From:
Sent: 19 November 2025 19:17
To: Louise Bearcroft; DC Admin
Subject: Formal objection - Planning Application No. 2025/44/92737/E

Re Planning Application No. 2025/44/92737/E

Re Plan number: [Drainage Plans \[id 1113906\]](#) 13/11/2025 - PV2511-APP-92-XX-DR-C-2501-P02 Flood Exceedance Plan

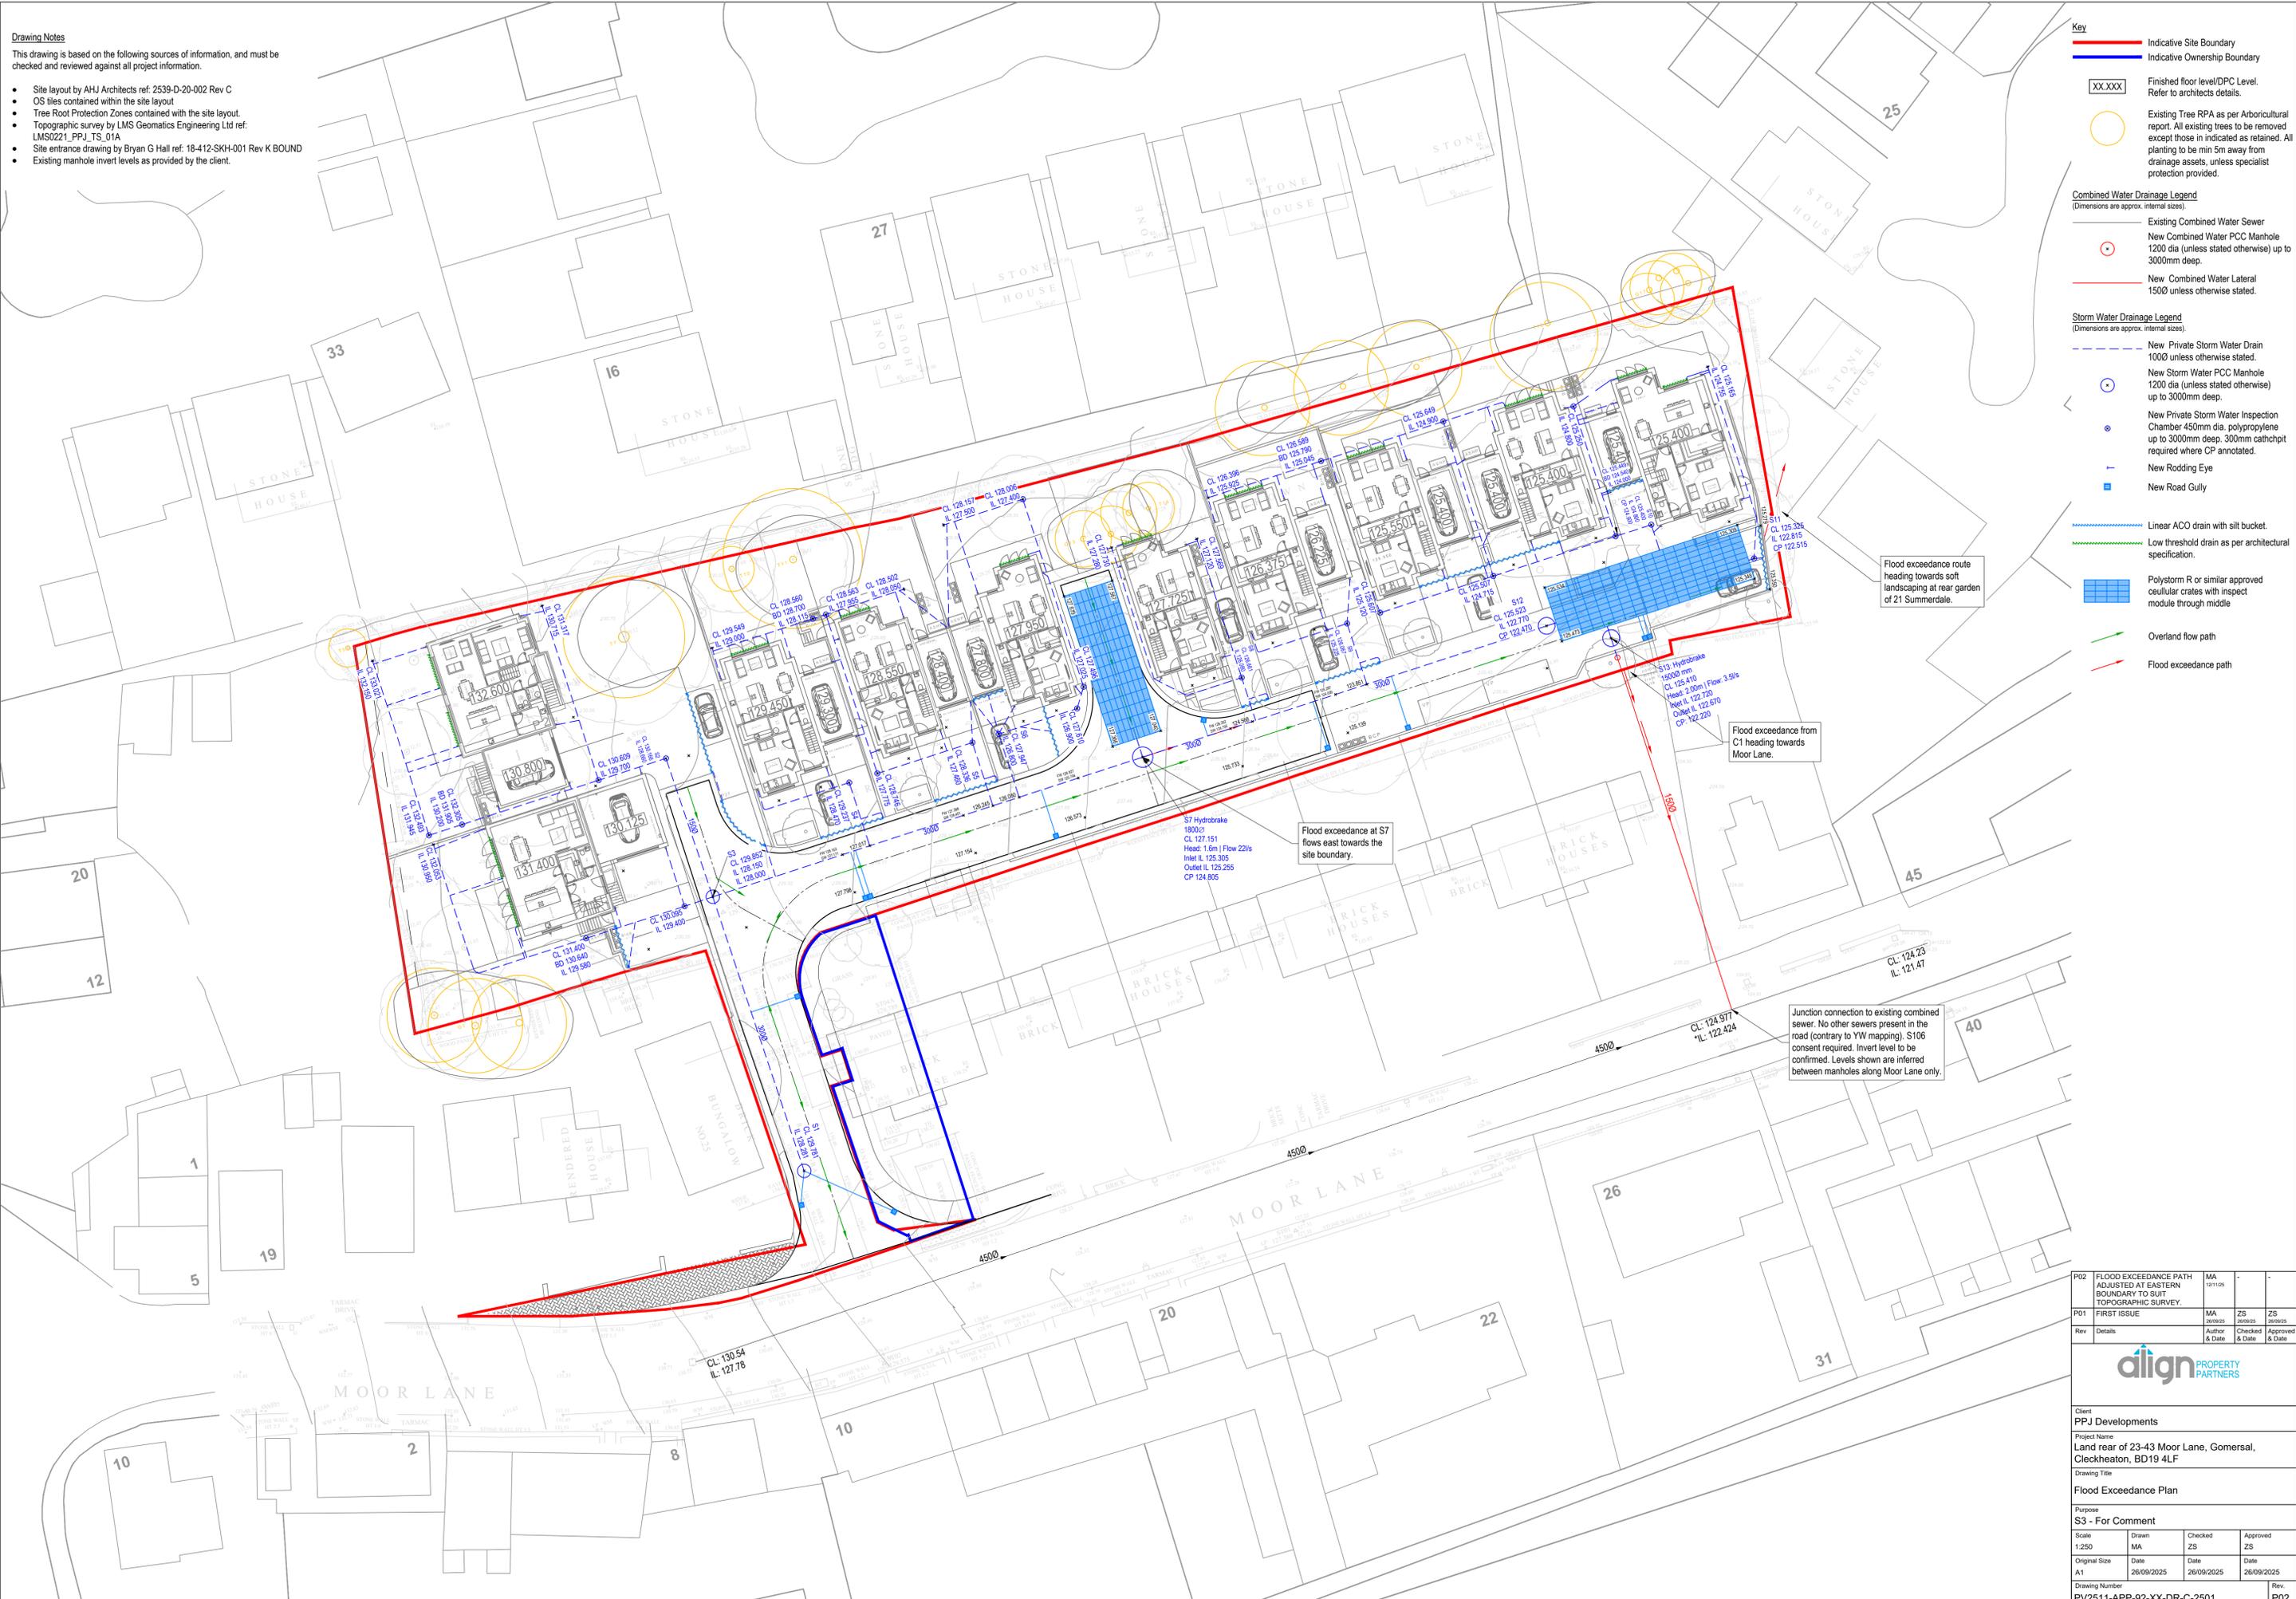
This plan is actually showing and stating that the flood exceedance route will be directed to 21 Summerdale's private garden. On the above plan, there is a red arrow indicating the direction of the flood exceedance flow and also states "Flood exceedance route heading towards soft landscaping at rear garden of 21 Summerdale".

This developer's flood exceedance plan, is clearly increasing the risk of flood to my property and is therefore not complying with the requirements of the National Planning Policy Framework.

A developer cannot unilaterally state that a flood exceedance route will be directed into a private garden without appropriate legal rights and permissions.

My husband and I have **not** been approached for permission to use our garden for this flood exceedance route and I am formally, informing you, Kirklees Council, that we do not give permission for this flood exceedance to be allowed to access our property.

facts provide you with evidence that there are no existing flooding issues at my property. Therefore this development's flood exceedance route **will** increase the flood risk at my property and **will** worsen the possibility of any flooding issues happening in the future.

I have been advised by Yorkshire Water that one of the requirements of the National Planning Policy Framework - Guidance - GOV.UK (NPPF) is that flood risk should not be increased elsewhere as a result of a development. Flood exceedance routes should not be designed to flow into a neighbouring private garden in a way that causes damage or increases flood risk. This developer is clearly doing this and as such will cause damage and increase the flood risk to my property.
